State of Washington  
**DEPARTMENT OF FISH AND WILDLIFE**  
South Central Region • Region 3 • 1701 South 24<sup>th</sup> Avenue, Yakima, WA 98902-5720  
Telephone: (509) 575-2740 • Fax: (509) 575-2474

April 21, 2021

**SUBJECT: WDFW COMMENTS ON LP-21-00001 BULL RANCH**

STEVE LATHROP
THE BULL RANCH
 PRELIMINARY SITE PLAN
 KITTITAS COUNTY WASHINGTON

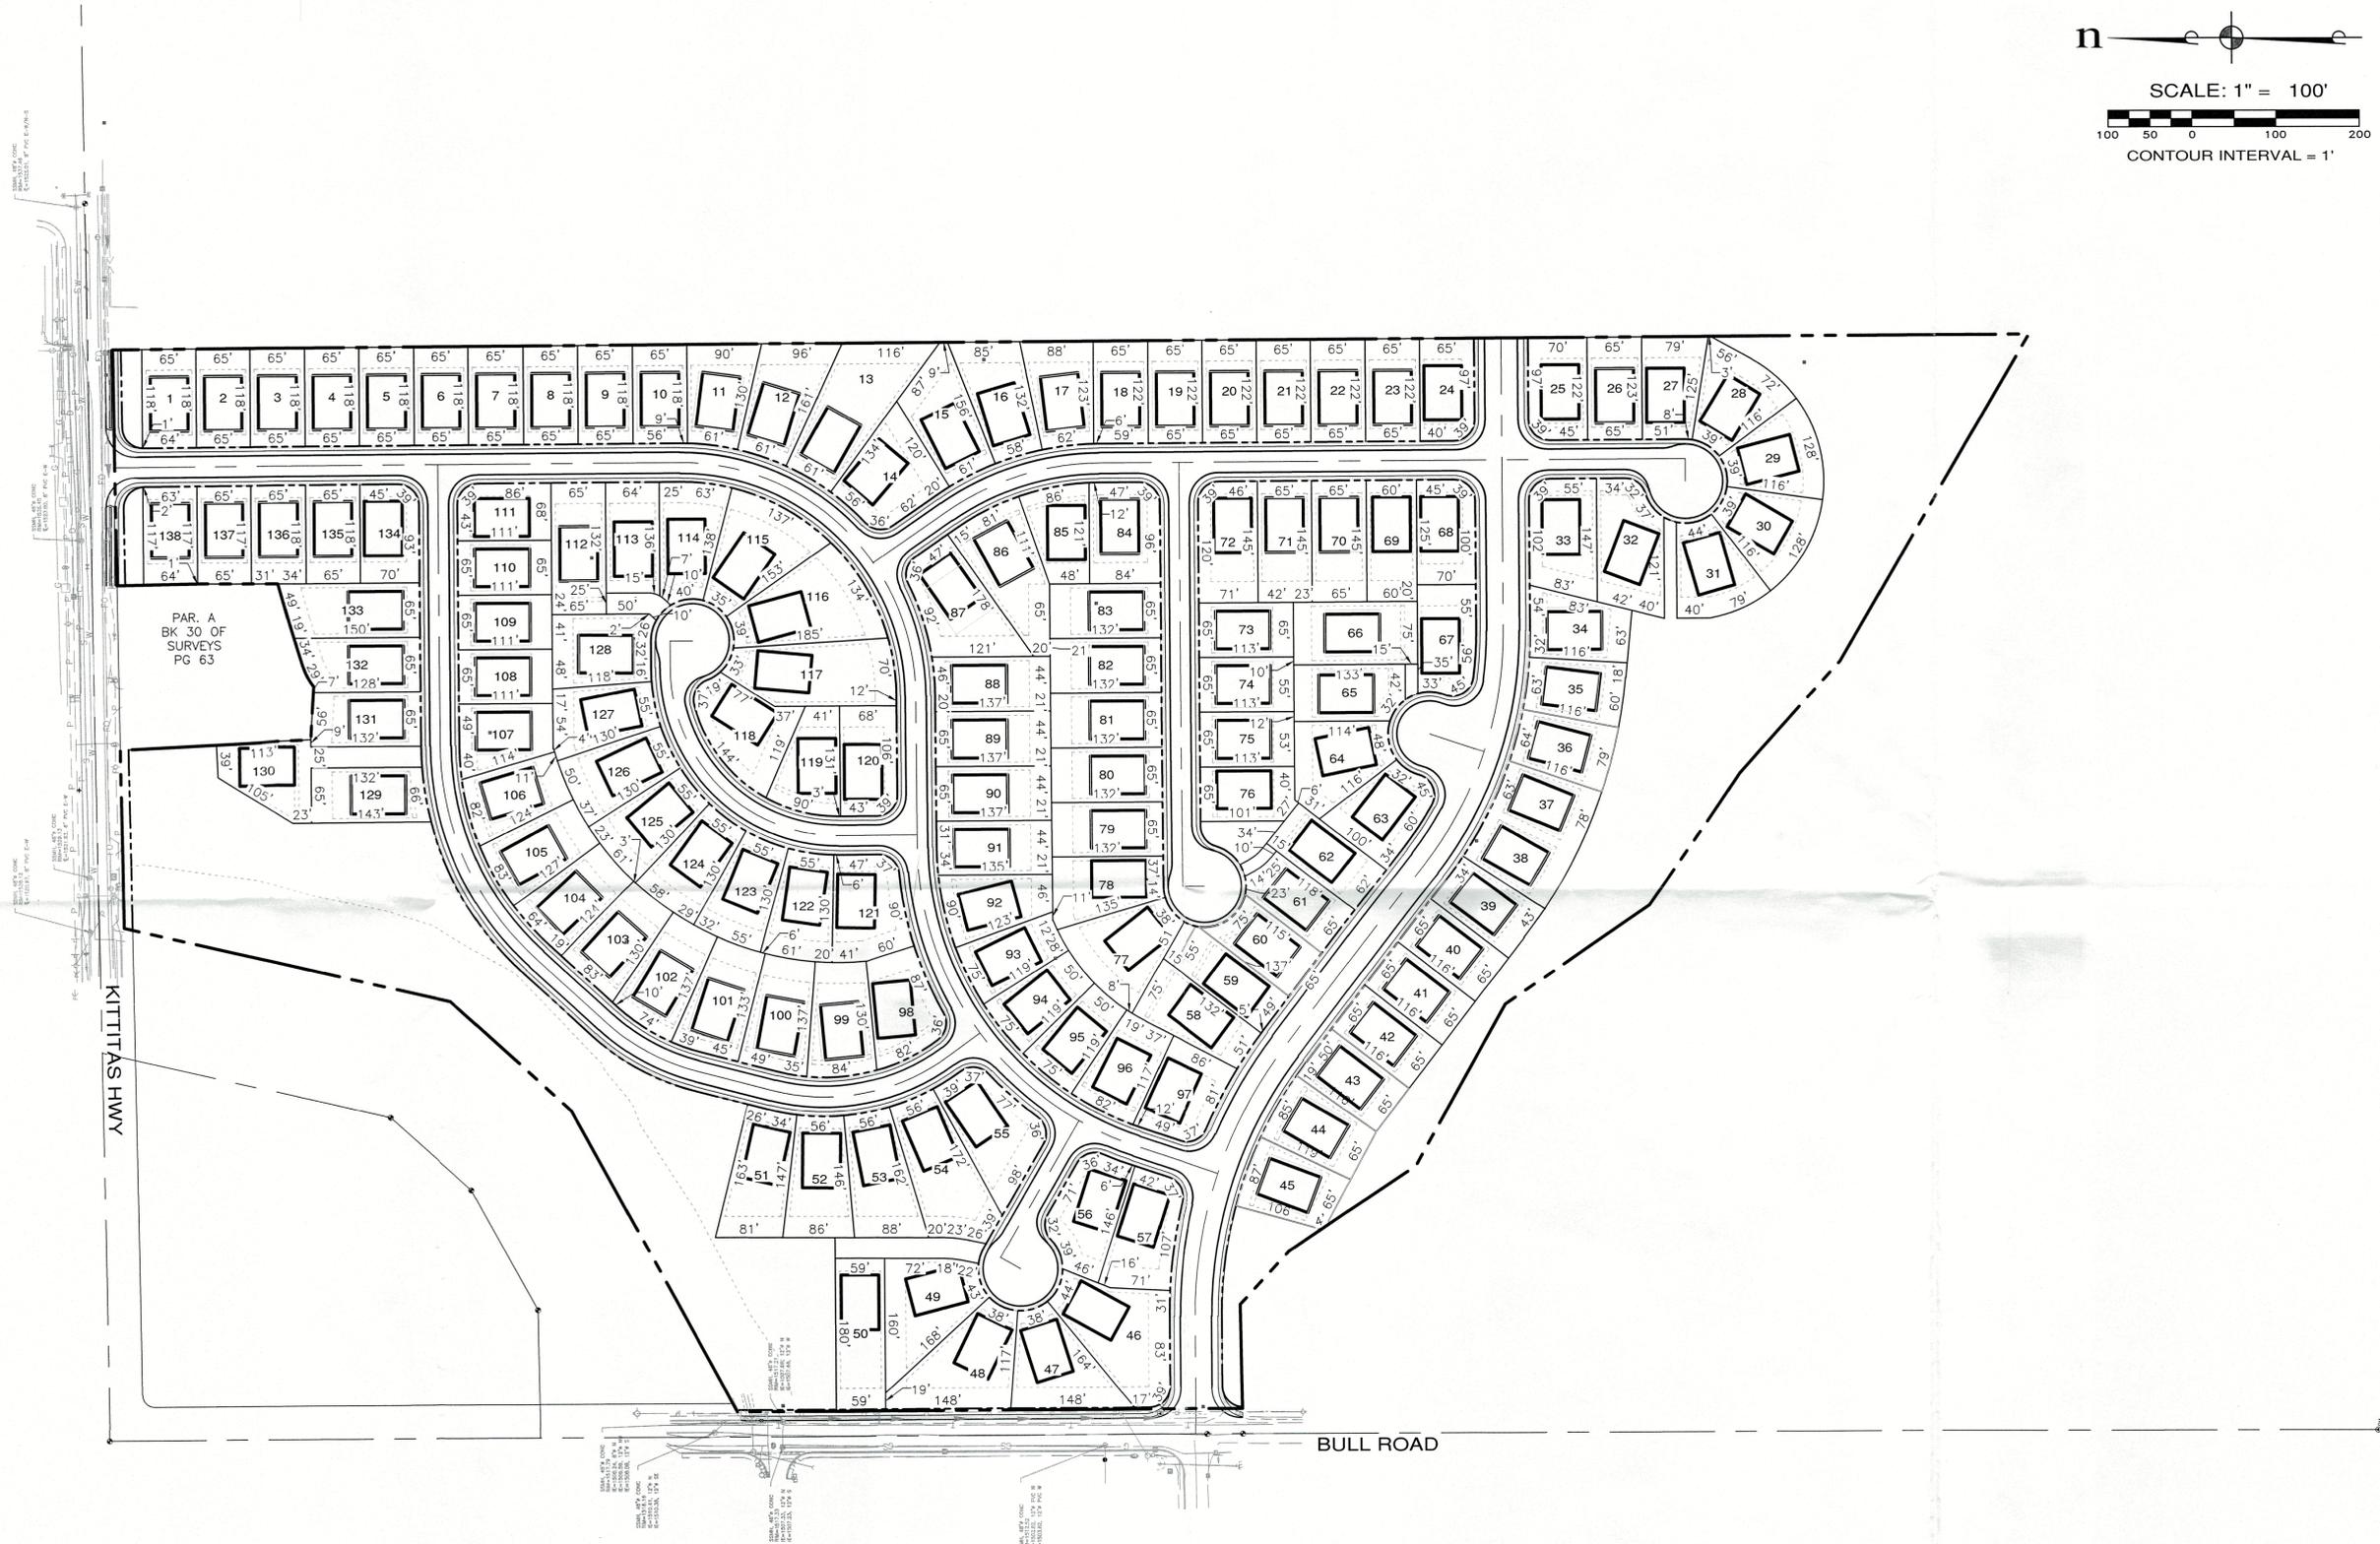
- Lyle Creek and its riparian habitat support a variety of fish and wildlife and these critical areas become even more important to wildlife movement and shelter as we develop the urban growth areas. For these reasons, **WDFW recommends that the critical area buffers be marked on all parcel maps and in the field such that future development avoids these areas.**

- Thank you for including Lyle Creek and the City of Ellensburg's 50-foot critical area buffer on the site plans. We acknowledge that the City's requirements are reflected in the site plans but that there appear to be **open space areas that could be planted with a variety of native plants to help provide more of the functions and values associated with the riparian ecosystem.** WDFW would welcome the opportunity to assist the project proponents with habitat enhancements to the stream, riparian ecosystem, and other open space areas throughout the development.
